Royal Worlington & Newmarket Golf Club

16th January 2026

I am Secretary to Royal Worlington and Newmarket Golf Club and I am writing to you regarding an application for a non-material change to The Sunnica Energy Farm Order 2024 (SI 2024/802), the deadline for submissions being 11.59pm on 16th January 2026.

I.3 Access and Rights of Way

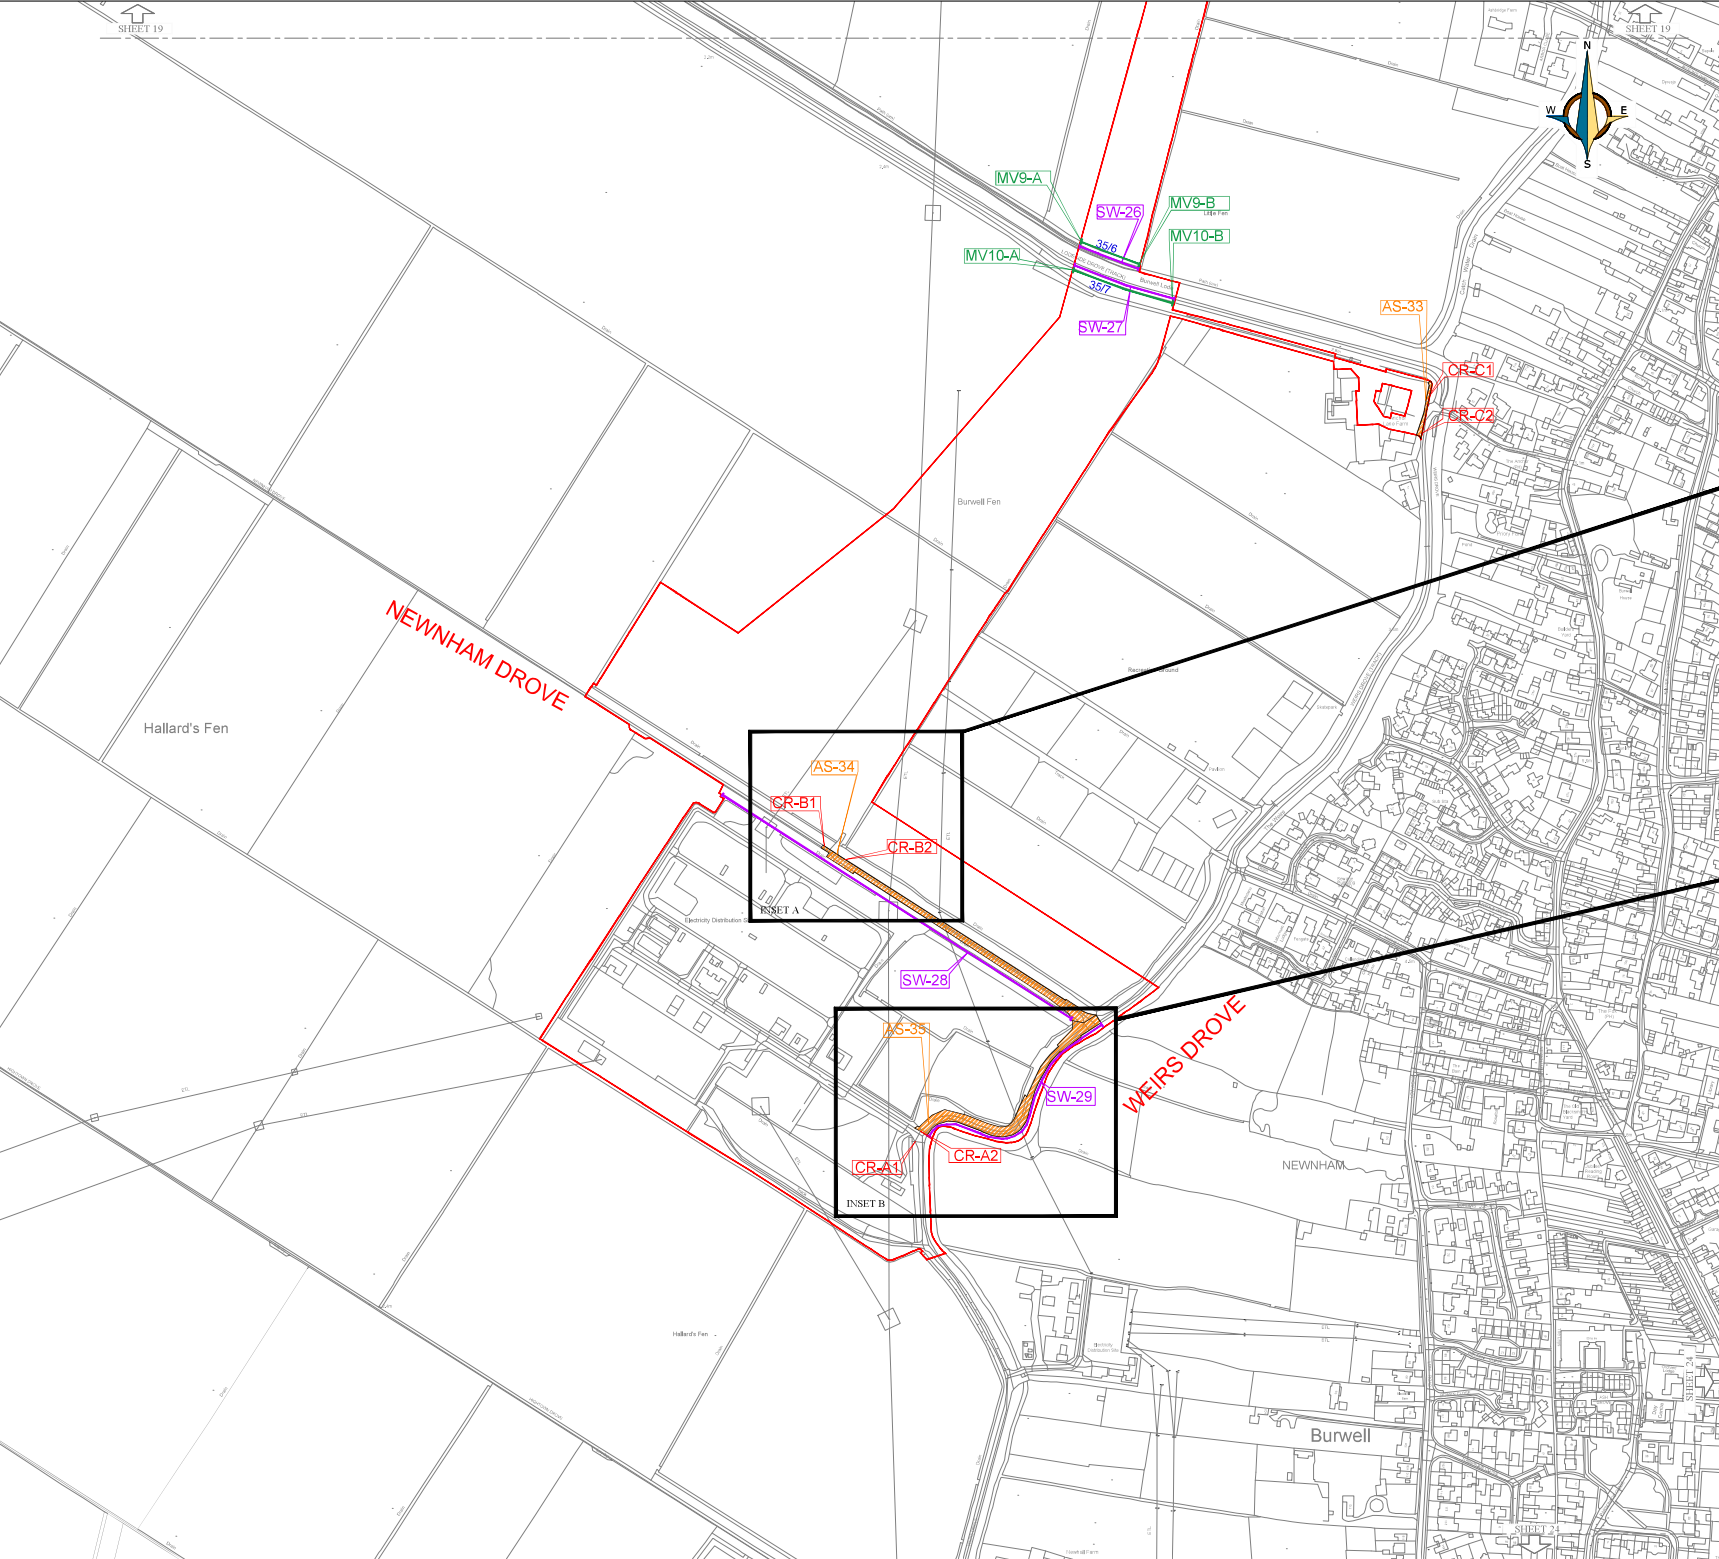
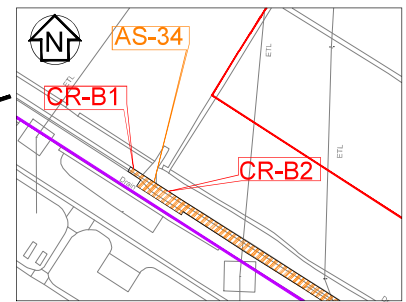
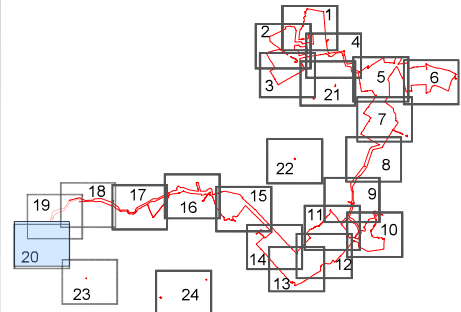
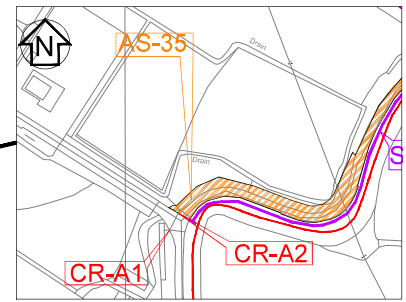
SEC Newgate agreed that this part of the scheme (Sunnica East) would be serviced via the junction off the A.11 with the Newmarket Road (Barton Mills). This is illustrated in the Access and Rights of Way Plan EN010106/APP/2.3, Plan 6 inset B. On the same plan, inset C illustrates the junction to service the western end of the scheme.

Inset A illustrates access to a "permissive route" which we interpret as being unsuitable to construction traffic. I would be grateful if you would provide clarity as to how you interpret traffic management in these instances and reconfirm that absolutely no use will be made of GLR during any part of the construction period.
